City of Portland, Maine – Building or Use Permit Application 389 Congress Street, 04101, Tel: (207) 874-8703, FAX: 874-8716

Location of Construction: 71 Central Ave. Peaks 04108		Owner: Dean Kamp		Phone: 766-2062		Permit No: 000903
Owner Address: Same		Lessee/Buyer's Name:		Phone:		
Contractor Name: Horizon Builders Inc.		Address: P.O. Box 802 Portland 04104		Phone: 879-9787		Zoning Approval: Special Zone or Reviews: <input type="checkbox"/> Shoreland <input type="checkbox"/> Wetland <input type="checkbox"/> Flood Zone <input type="checkbox"/> Subdivision <input type="checkbox"/> Site Plan maj <input type="checkbox"/> minor <input type="checkbox"/> mm <input type="checkbox"/>
Past Use: Single Family		Proposed Use: Same		COST OF WORK: \$ 10,000.00		
Proposed Project Description: Construct Bedroom		FIRE DEPT. <input type="checkbox"/> Approved <input type="checkbox"/> Denied		INSPECTION: Use Group: Type:		Signature: _____ Date: _____
				Signature: _____		
Permit Taken By: Gayle		Date Applied For: GD August 11, 2000		PEDESTRIAN ACTIVITIES DISTRICT (P.A.D.) Action: <input type="checkbox"/> Approved <input type="checkbox"/> Approved with Conditions <input type="checkbox"/> Denied		Zoni

NEW SECOND FLOOR

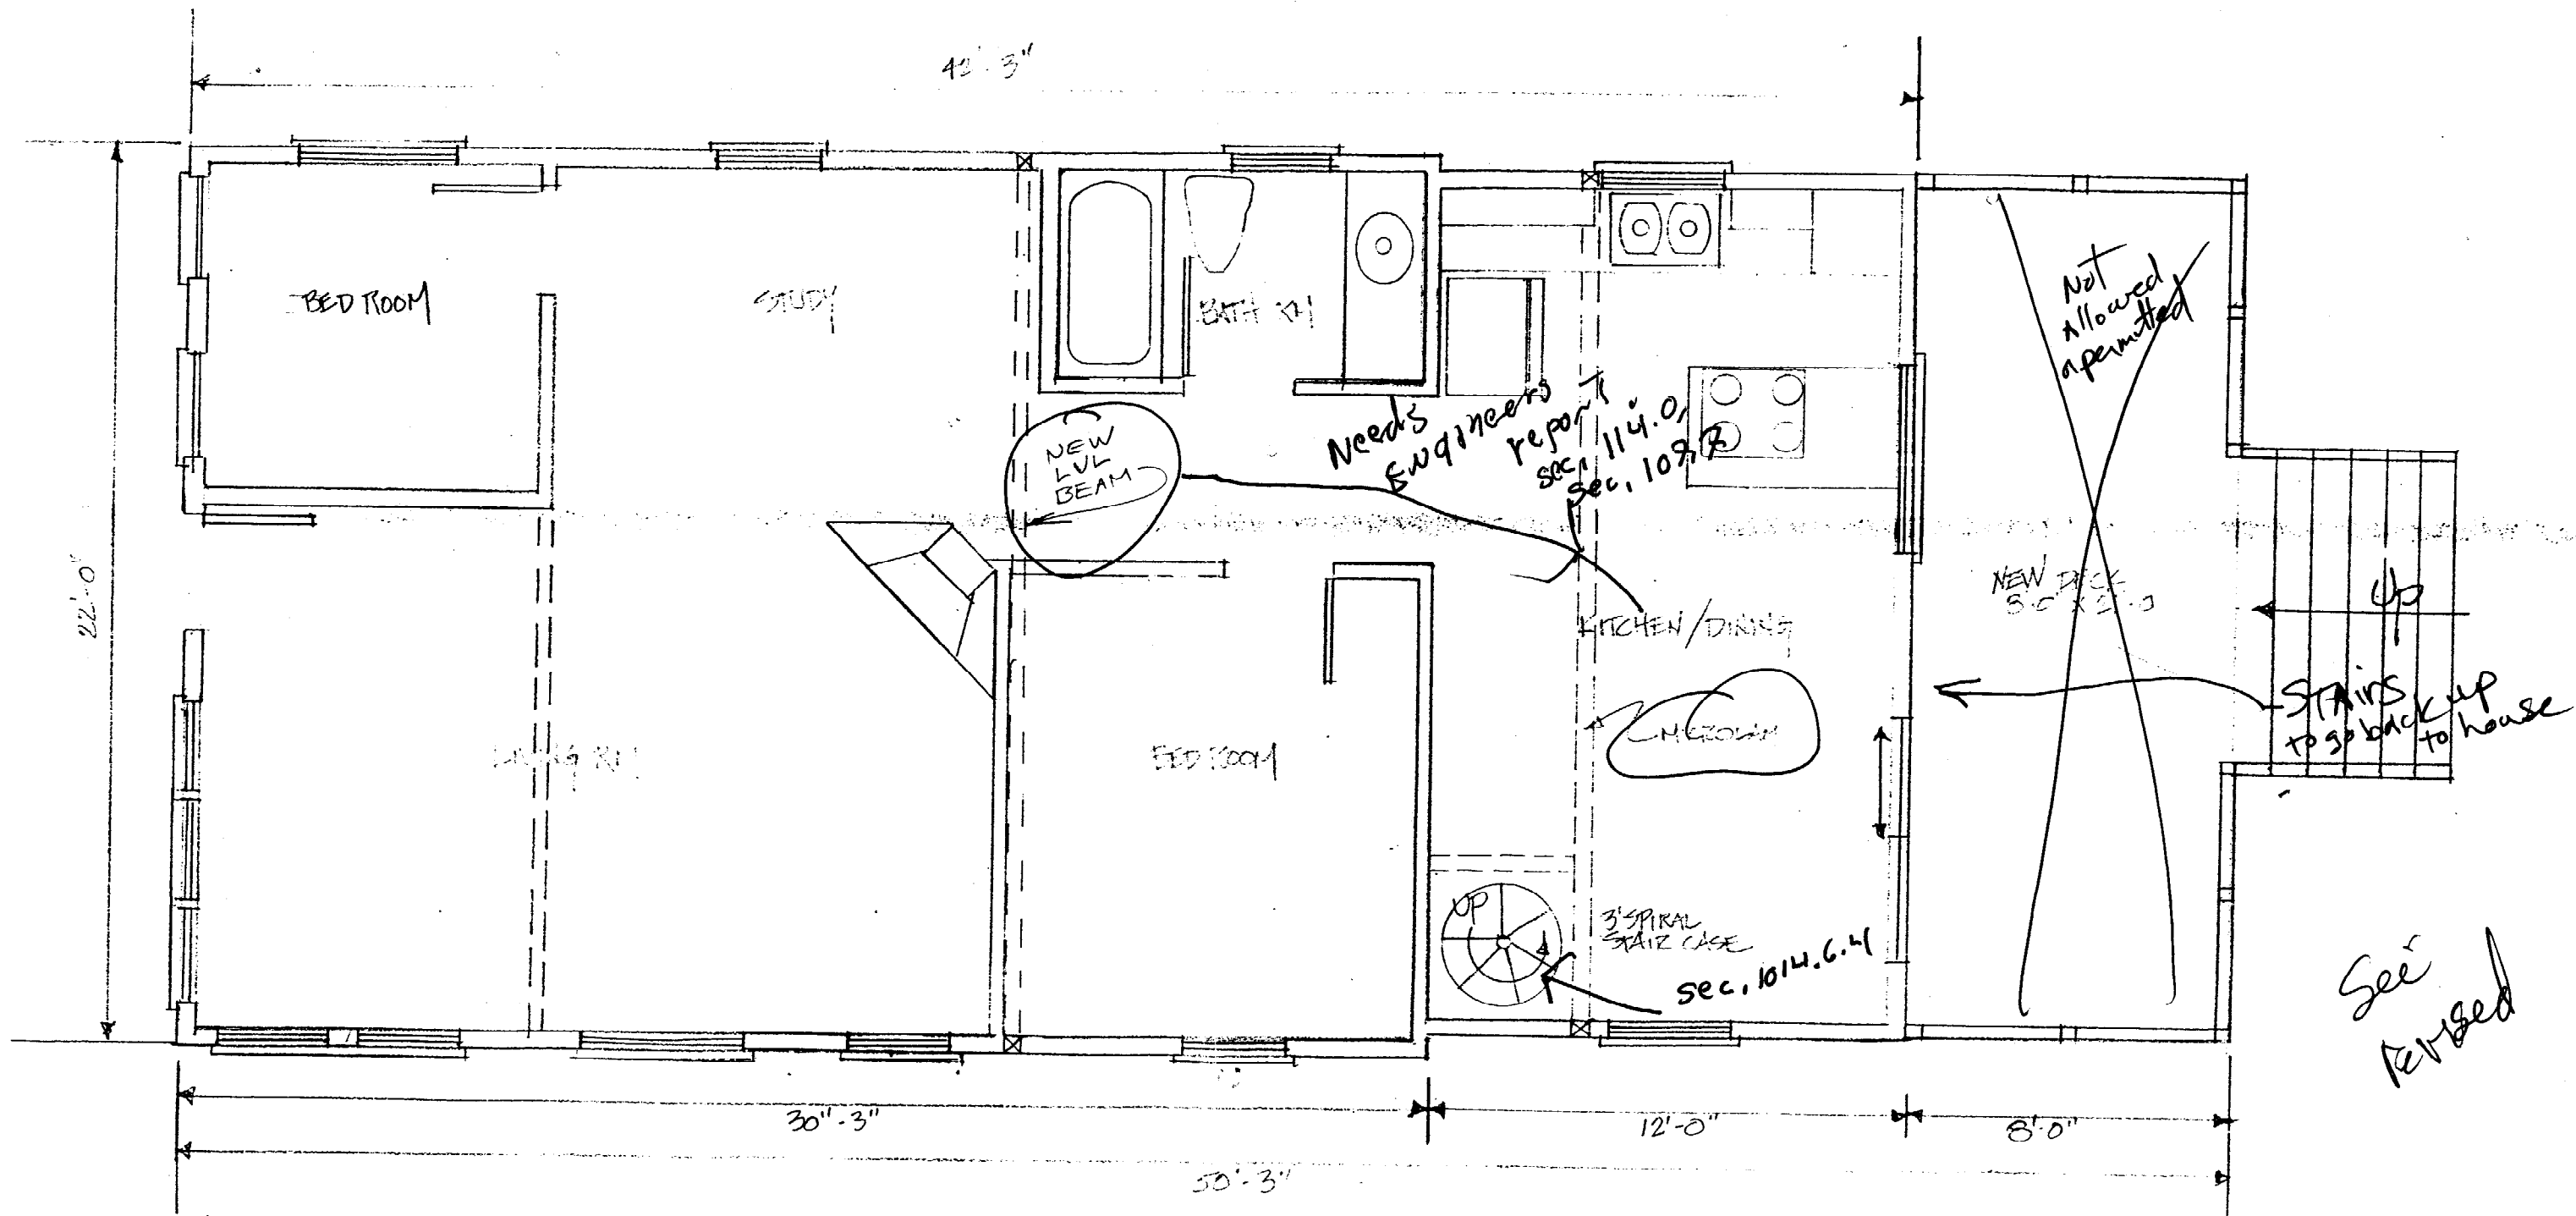
Egress or rescue bedroom window
Sec. 1010.4

Guardrail
Sec. 1022.0

stairs existing
Handrails
Sec. 1021.0

Guardrails
Sec. 1022.0
New Deck Deleted

Stair Guard Sec. 1014.0
